South Holland District Council

**Re: Reserved Matters Application for Residential Development of 60 Dwellings
Land Off Nightingale Way Sutton Bridge – H18-1167-19**

We refer to recent email communications and in particular your email dated 2nd January 2020 raising various comments and queries. This letter responds in detail to the points raised in the same order presented within your email.

FLOOR PLANS & ELEVATIONS
HOUSE CODES: 1b2s_A / 2b2s_B

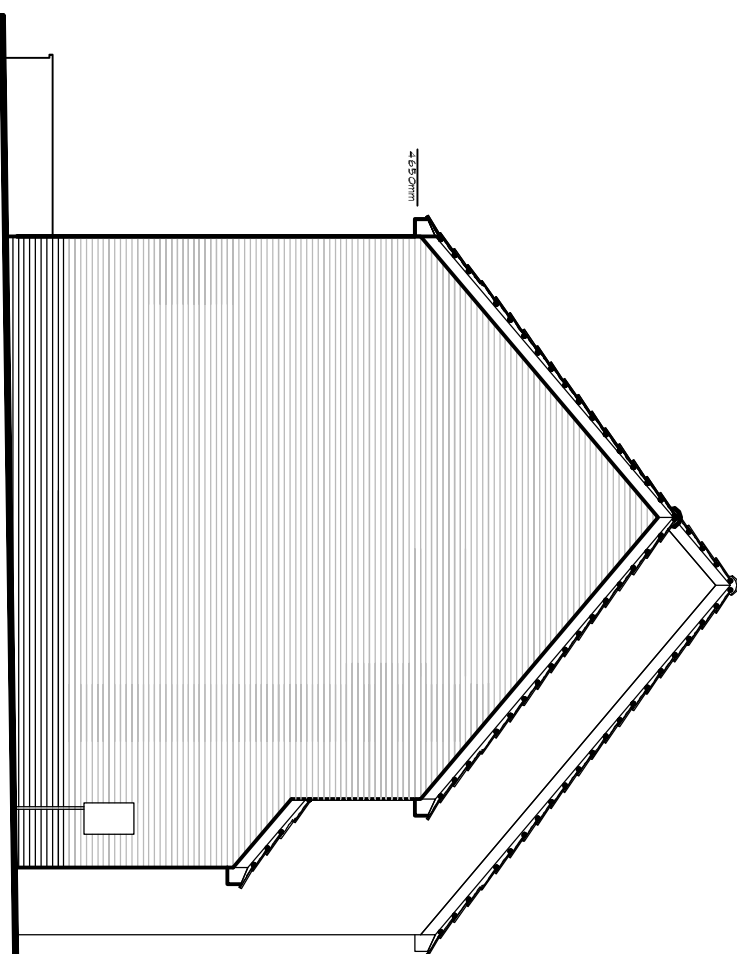
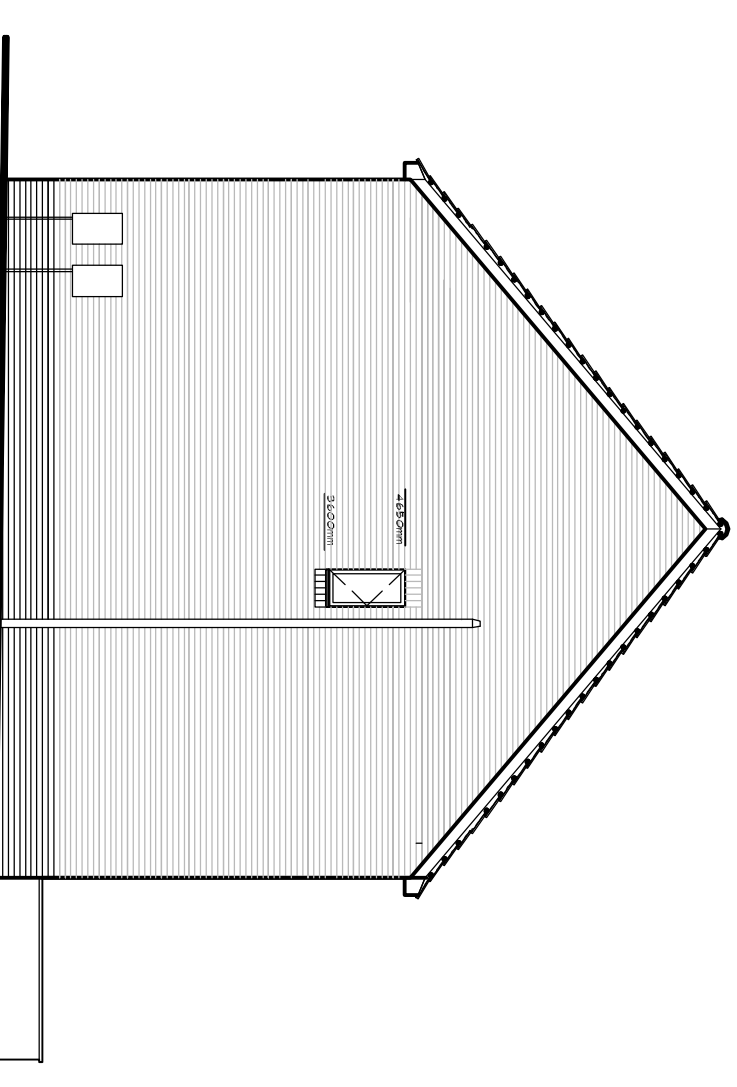
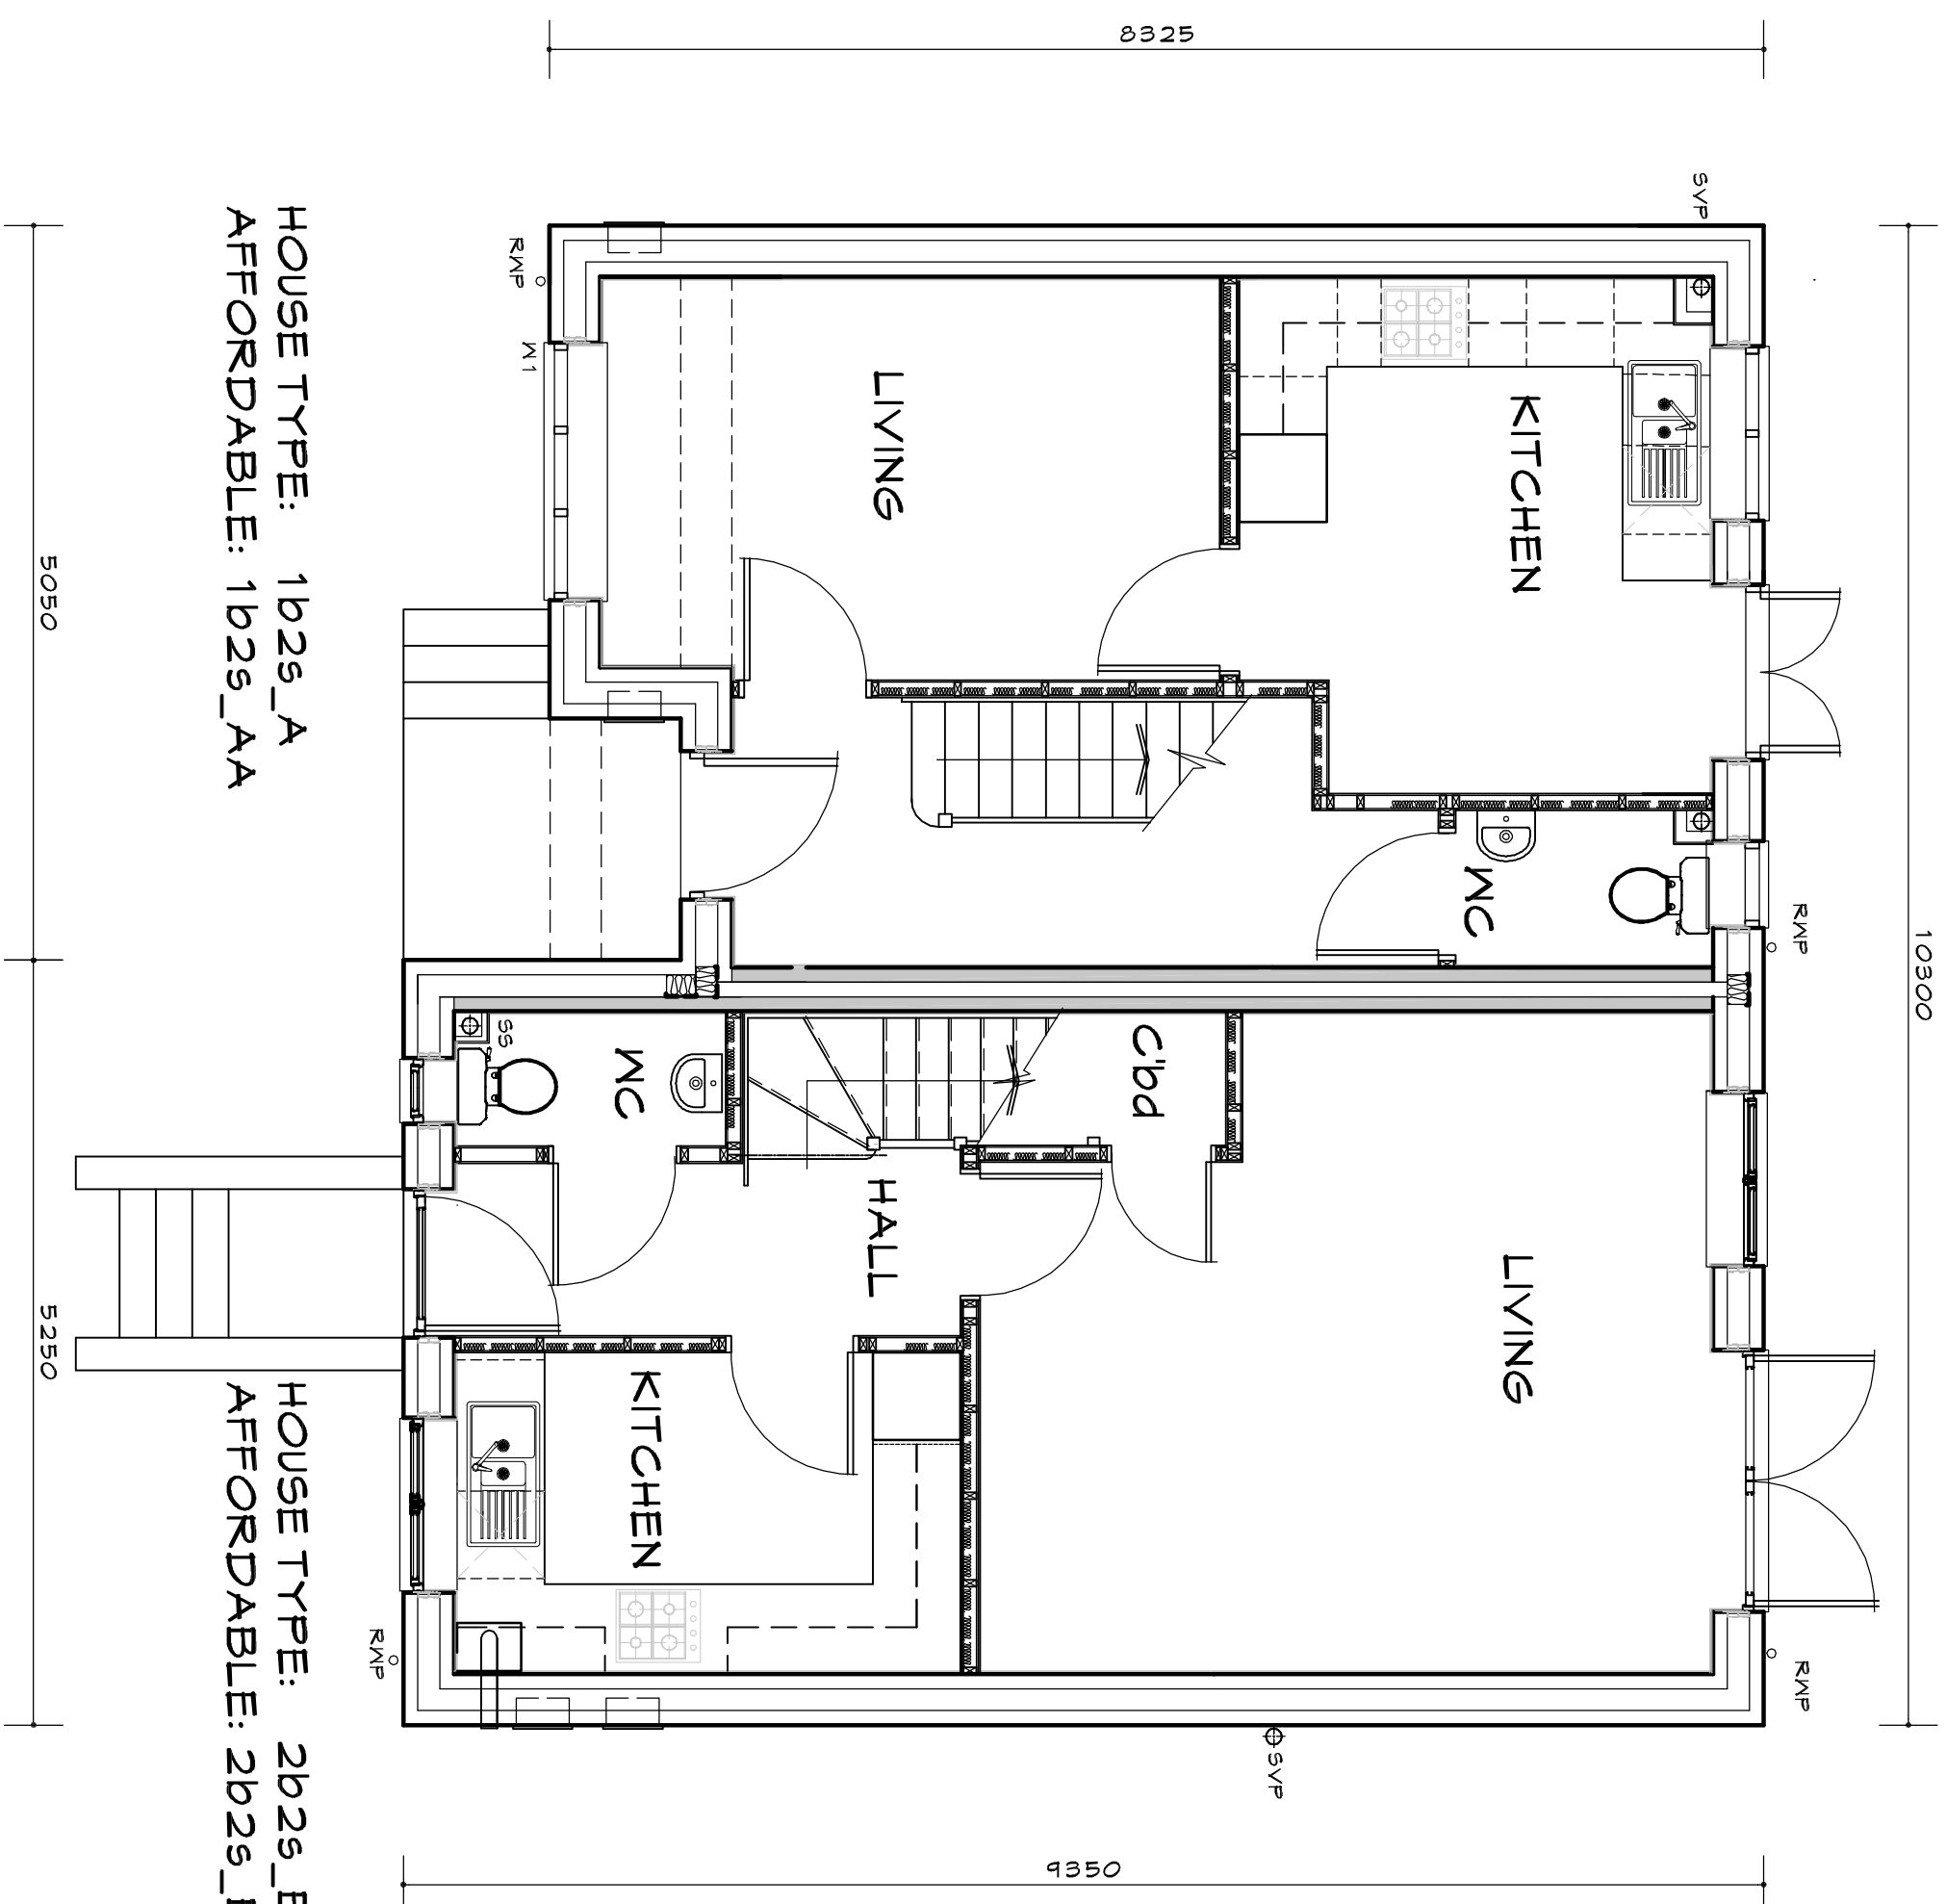
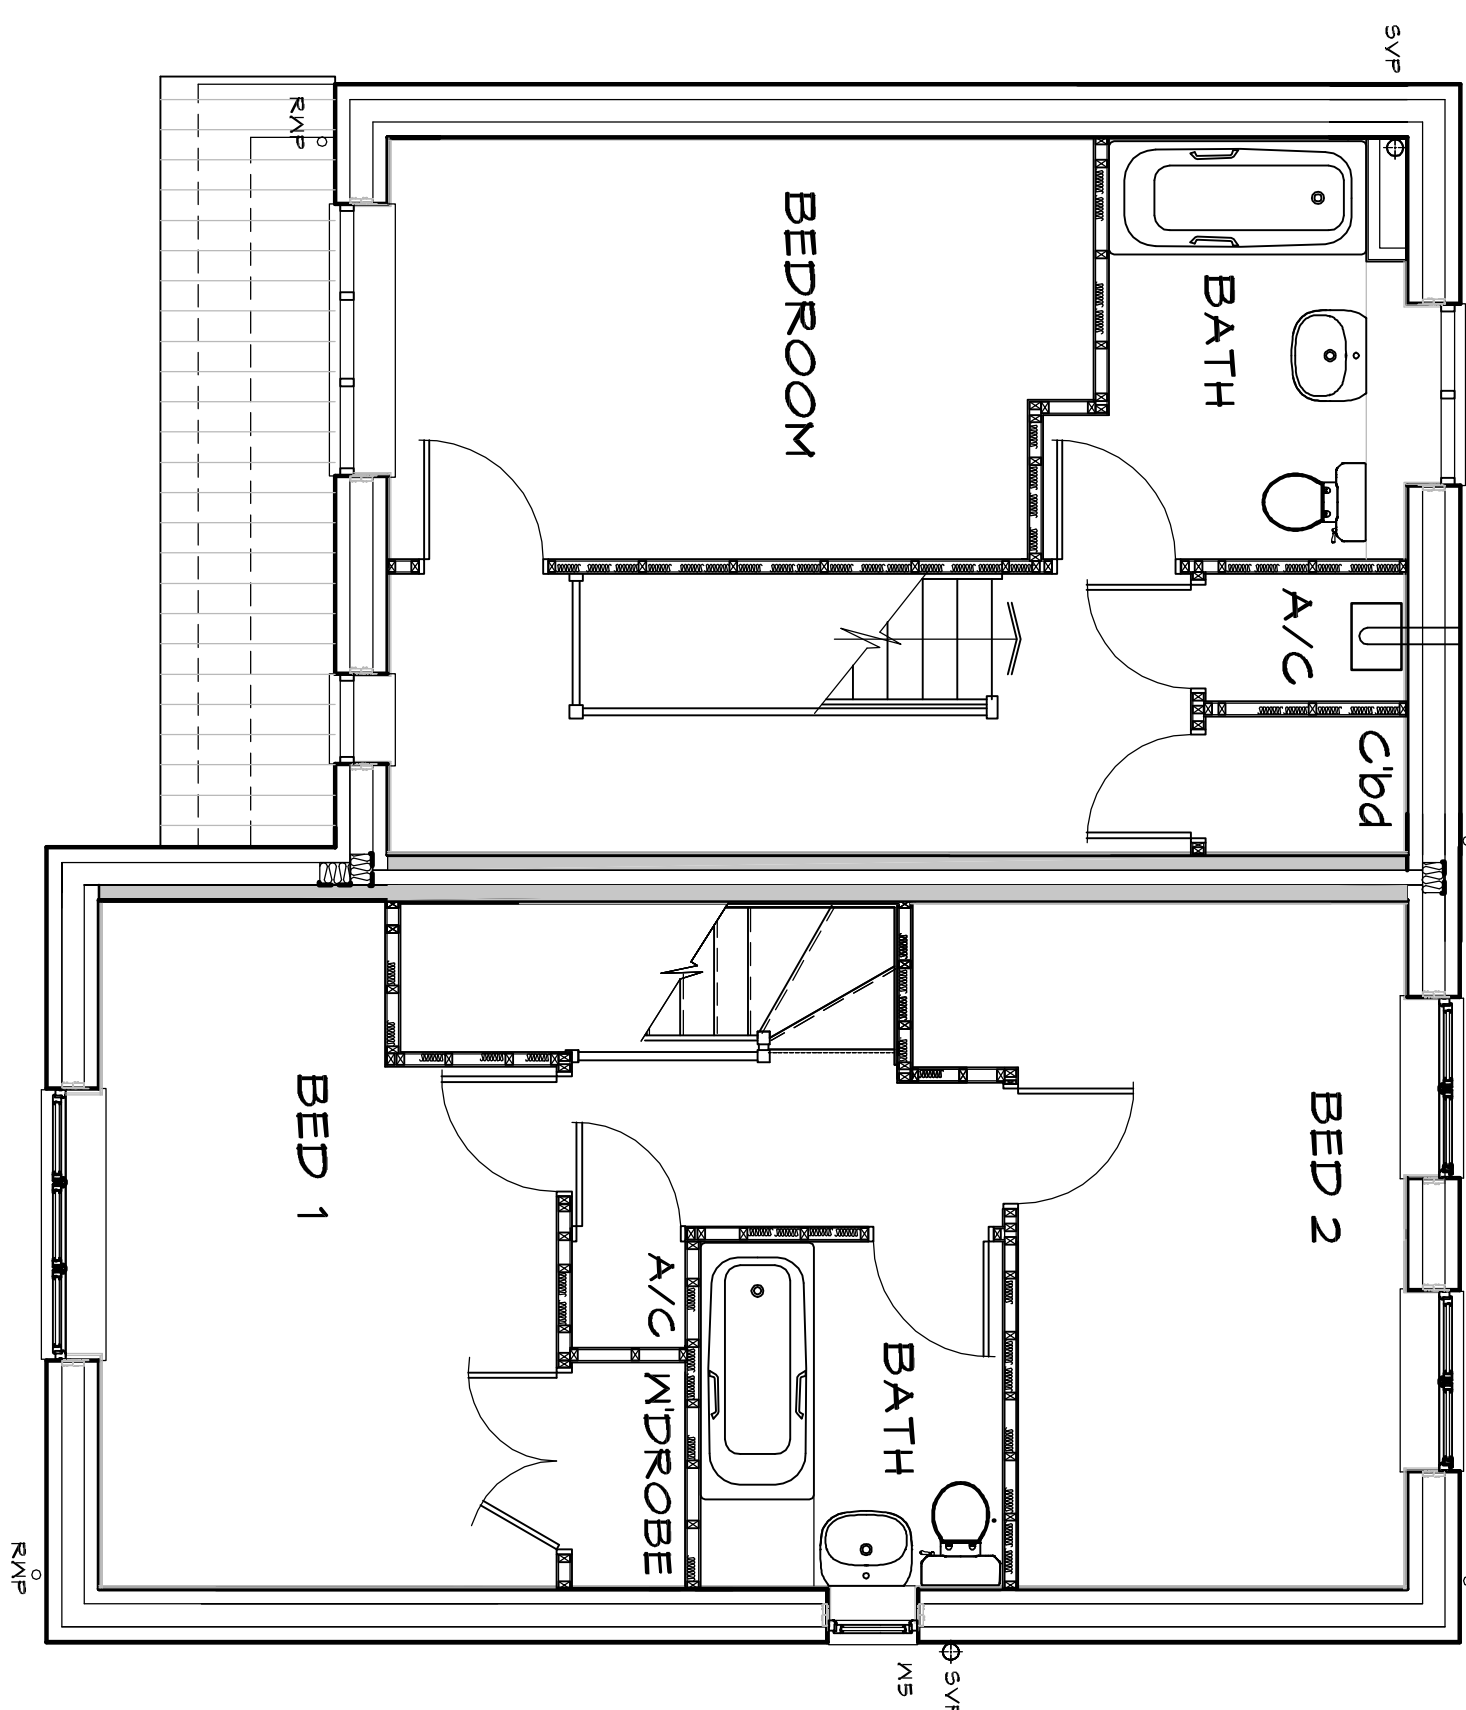
7.01 The discrepancies noted have been rectified and revised drawings are now enclosed for house designs 1b2s_A/2b2s_B, 3bdd_A and 3b2s_AA.
